PLANNING APPLICATION No: 3/12/0268

Application: Proposed two storey side and rear extension and single storey sun room extension to rear

At: 8 PARSONAGE AVE. RIBCHESTER

Proposed Plans and Elevations

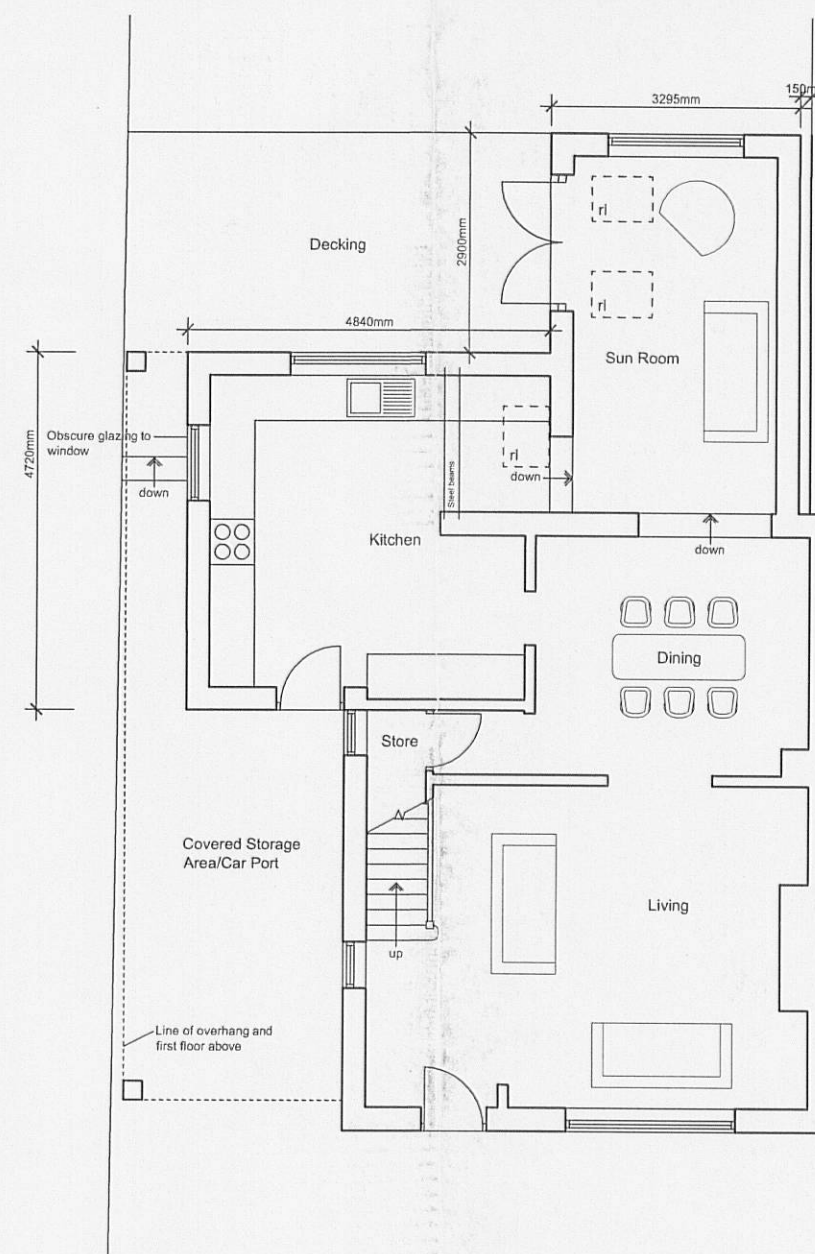
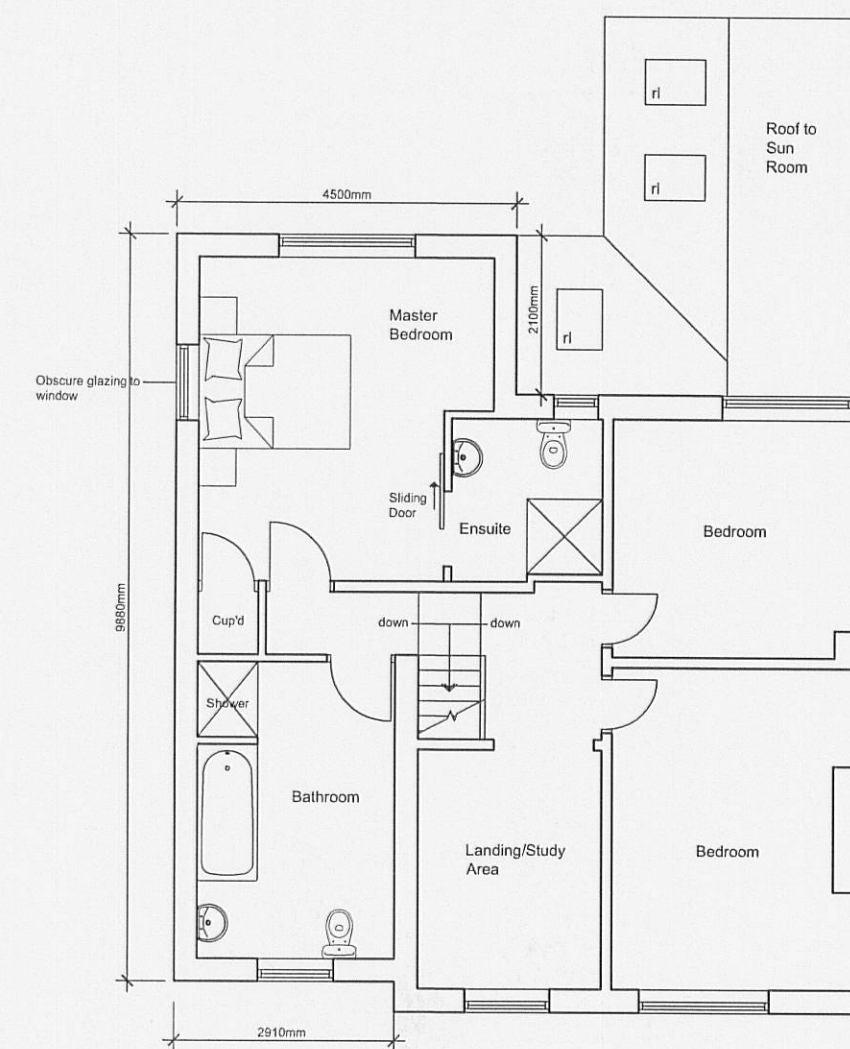
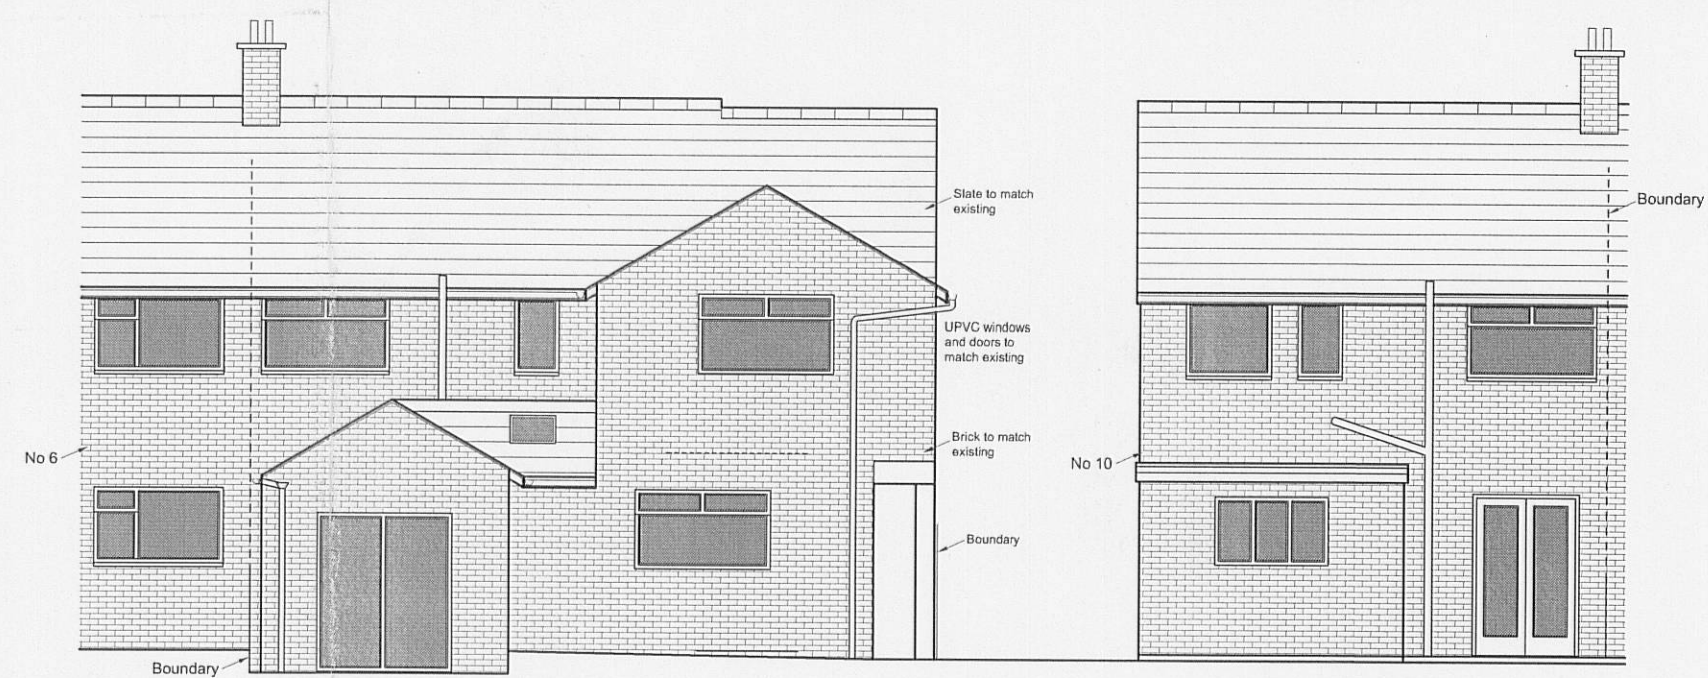
In the consideration of this application the Parish Council has taken note of the comments of planning officers posted on similar extensions in the locality. While the design and orientation of the two storey side and rear extension is unlikely to cause much loss of light to No. 10 there is concern that the addition of a sun room to the rear may result in some loss of light to No.6.
